NORTH WALES WINDFARM OVERHEAD LINES EXAMINATION DEADLINE 3 SUBMISSION – DENBIGHSHIRE COUNTY COUNCIL

IN RELATION TO SOCIO - ECONOMIC IMPACTS HEARING, 1ST OCTOBER

- DETAILS OF SECTIONS OF SP MANWEB APPENDIX REFERRED TO IN COMMENTS ON INTERPRETATION OF SURVEYS, AND USE OF % FIGURES

Figure 11.9 Predicted Future Level of Business Trading

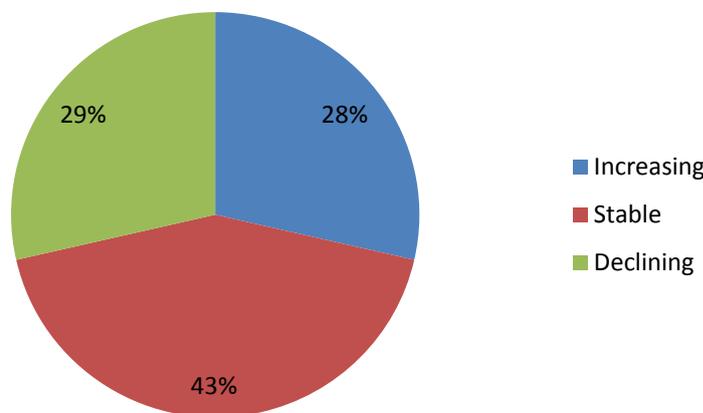
11.6.20 – poorly worded. Fig 11.9 – I think 14 have answered this question 4, 4, and 6 make sense so the 28% and 29% represent the same number.
